# LSC Responses to TIS REDLINE Comments

## Nabulsi-Abushaban Subdivision Traffic Impact Study (LSC #S224340) November 3, 2023

Figure 3

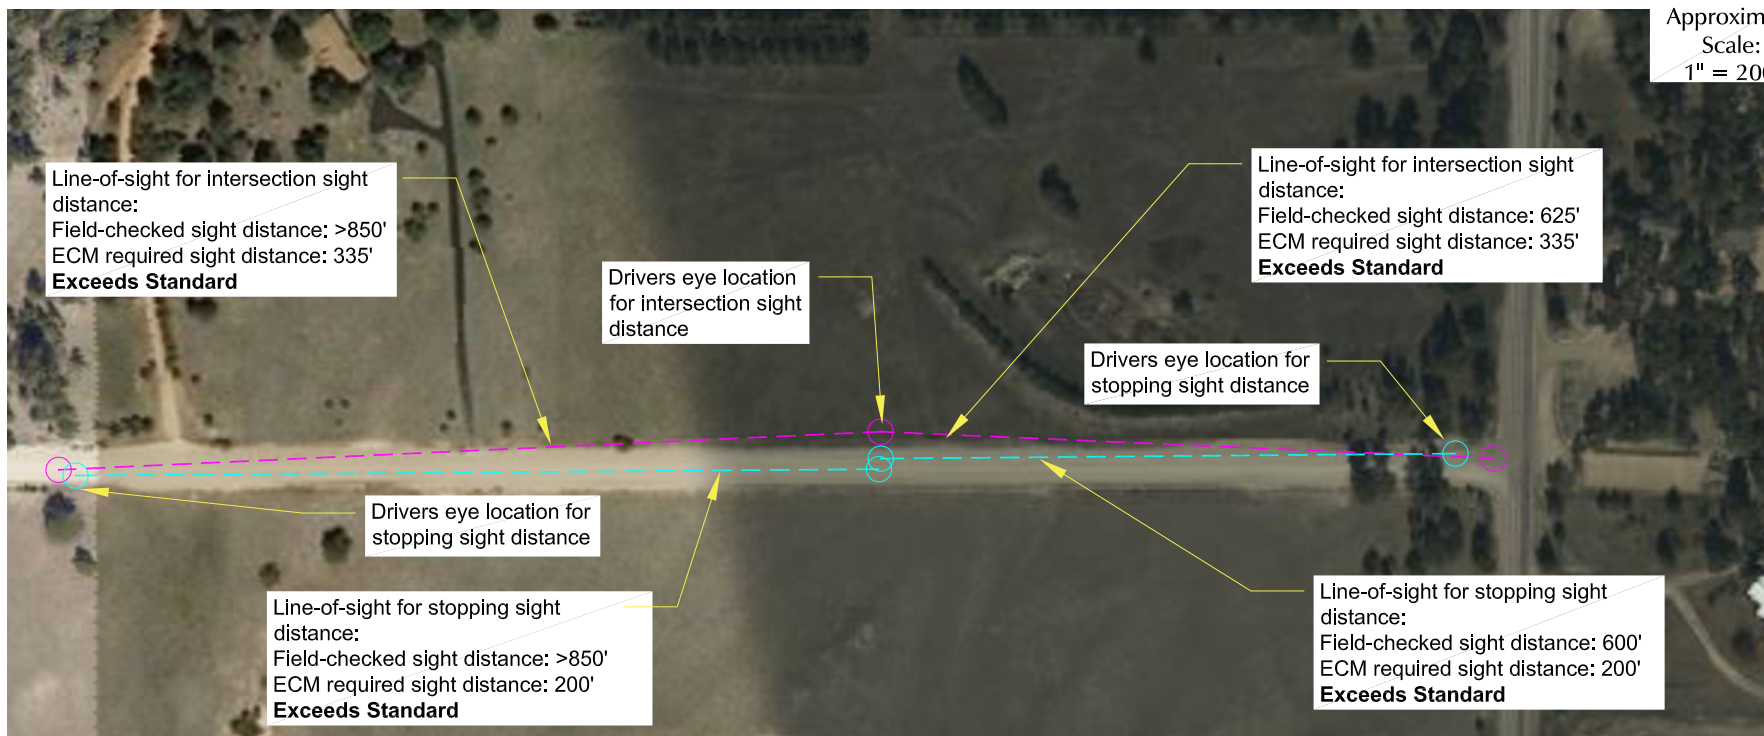
1 Please see comment regarding line of sight distance for intersection and stopping sight distance and revise accordingly.
